From: Laura Gibbons <Laura.Gibbons@arun.gov.uk>
Sent: 07 December 2021 14:10
To: Planning.Responses <Planning.Responses@arun.gov.uk>
Cc: Anita Gardner <Anita.Gardner@arun.gov.uk>
Subject: RE: Planning Consultation on: F/22/21/PL

Engineers Comments Regarding Surface Water Drainage

Application No: F/22/21/PL

Site Address: Land rear of Paynters Croft Burndell Road Yapton BN18 0HR

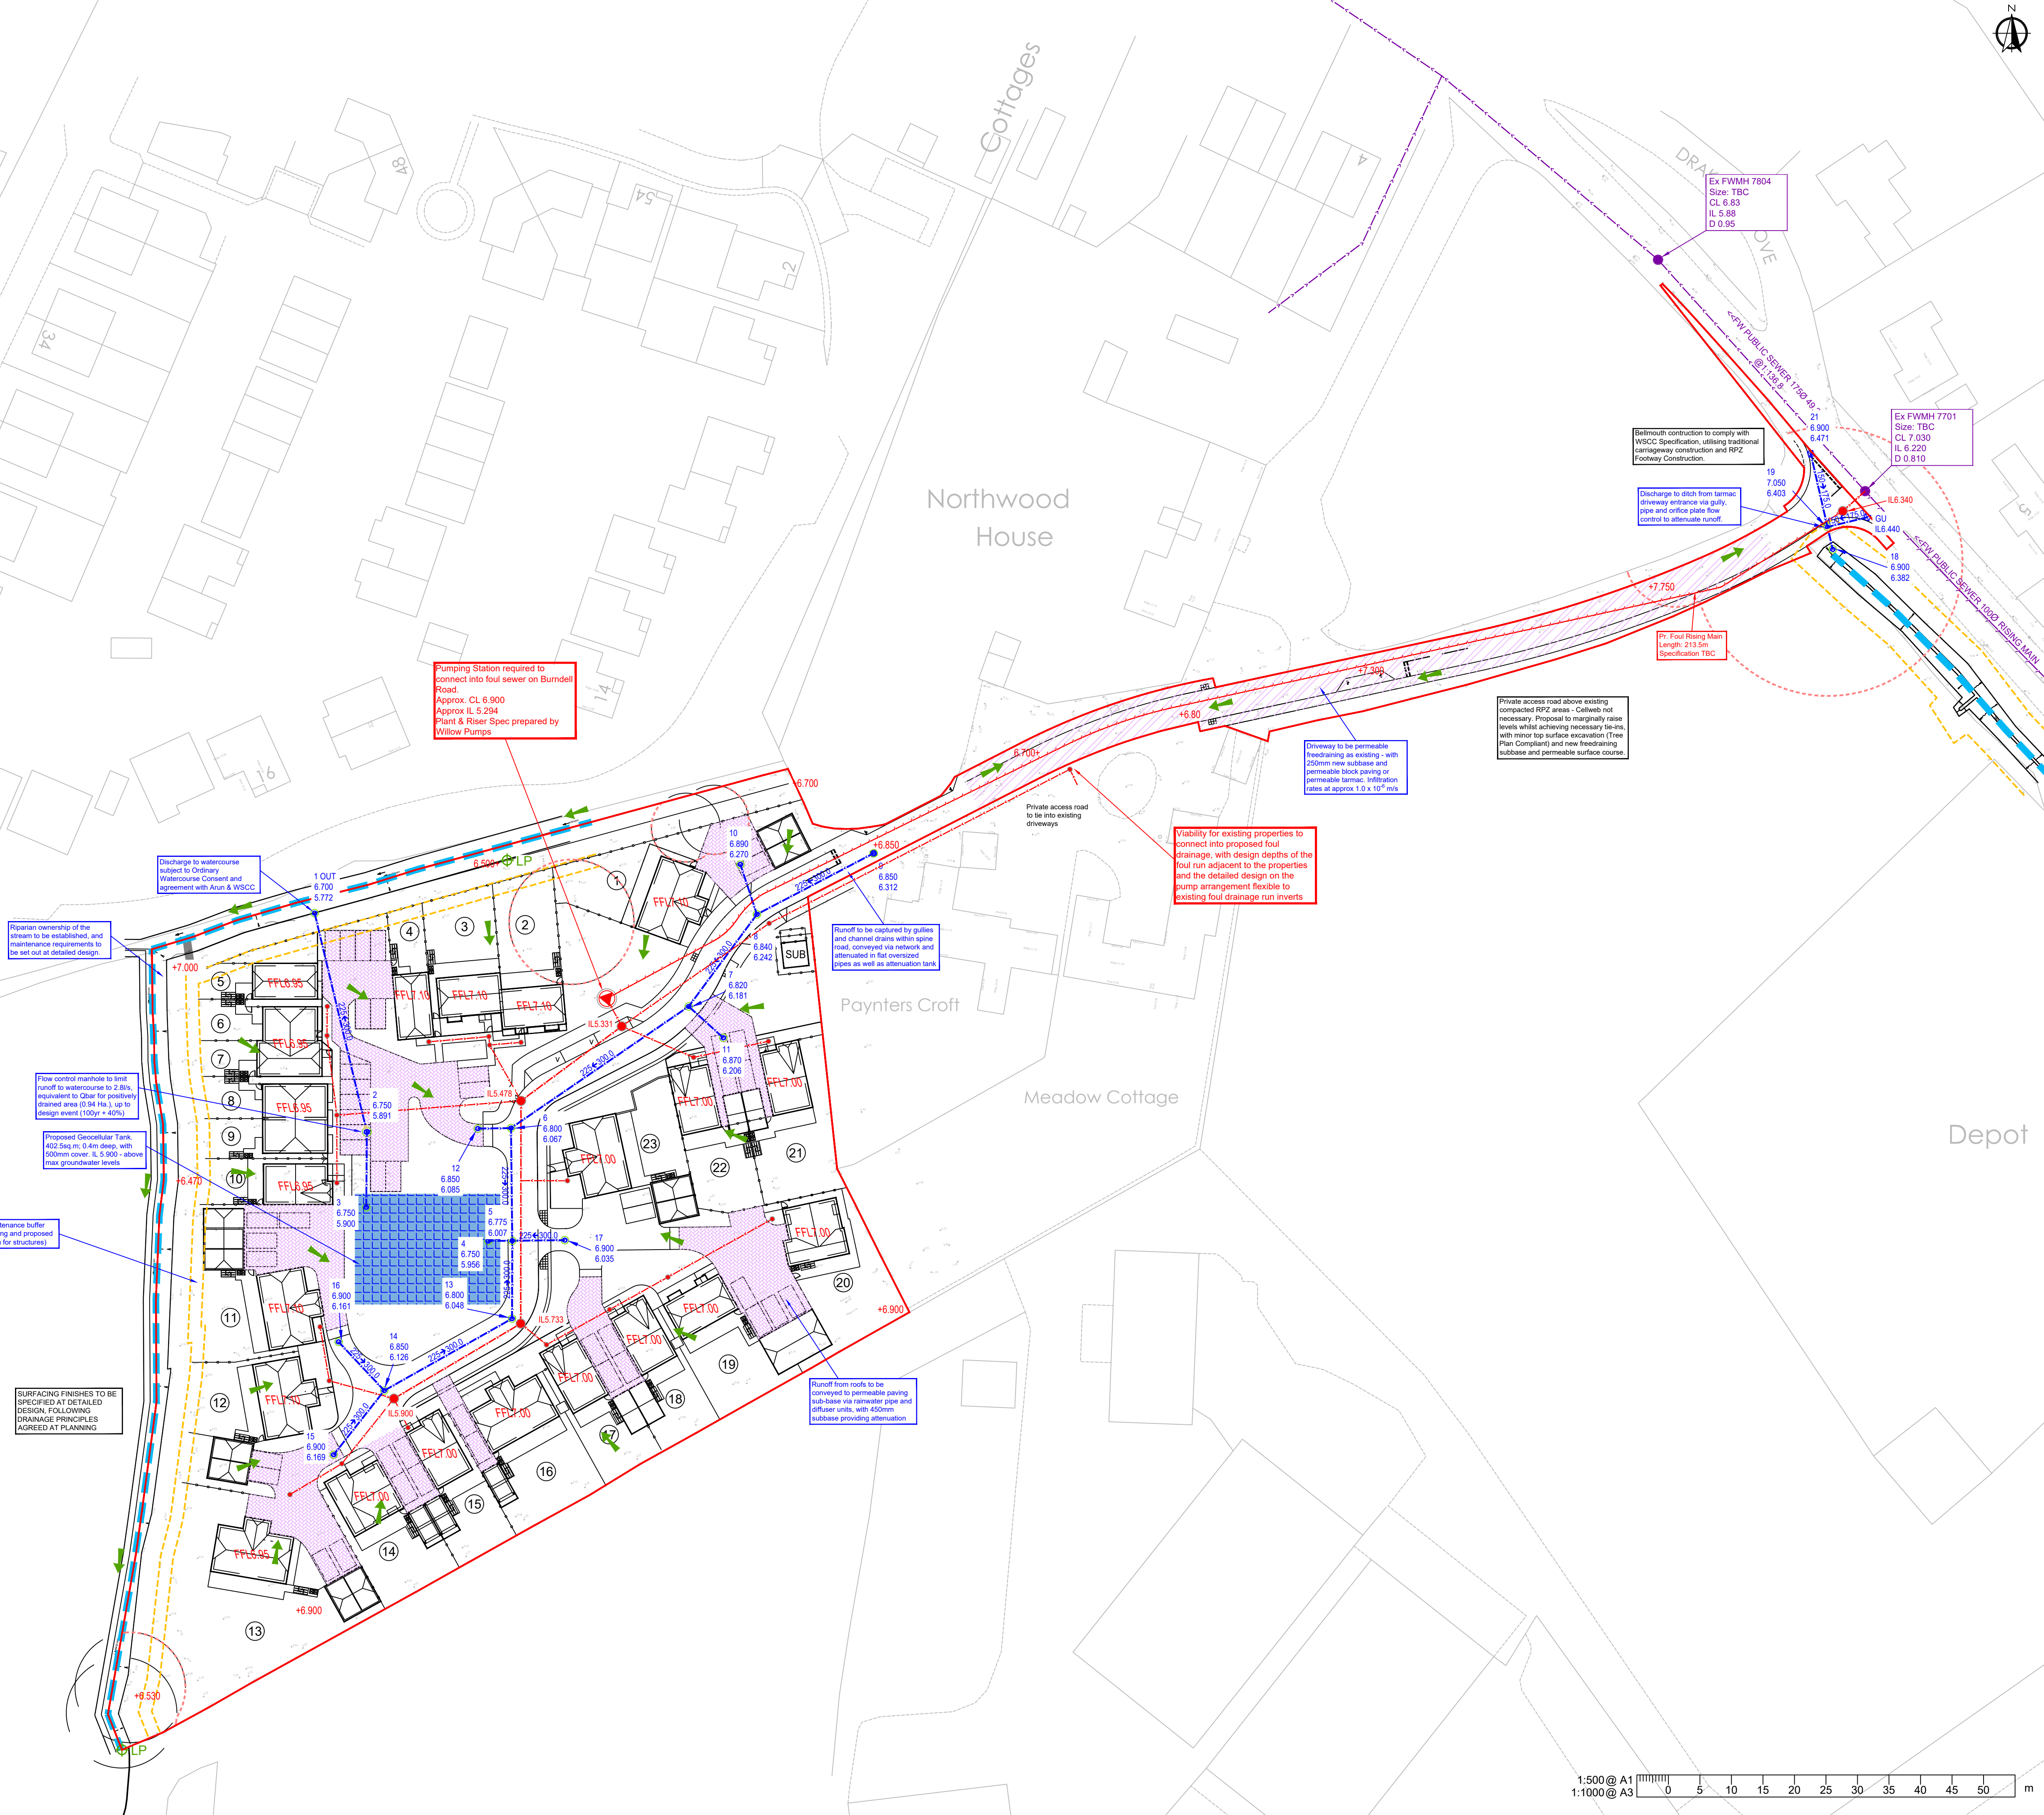
A drainage strategy has been supplied as part of this application. This rules out infiltration due to the presence of shallow groundwater. Groundwater monitoring was completed in the winter of 19/20 and found groundwater to be as shallow as 0.29mbgl. We agree that attenuated discharge to watercourse is required at this location. The proposed discharge rate is not based upon the area which is proposed to be positively drained. We request that greenfield runoff rates are recalculated based upon the positively drained area, and that a revised drainage strategy is supplied. This is required to evidence that there is sufficient space within the proposed layout for surface water drainage.

1. Revised discharge rate calculations and an updated surface water drainage strategy based upon this.
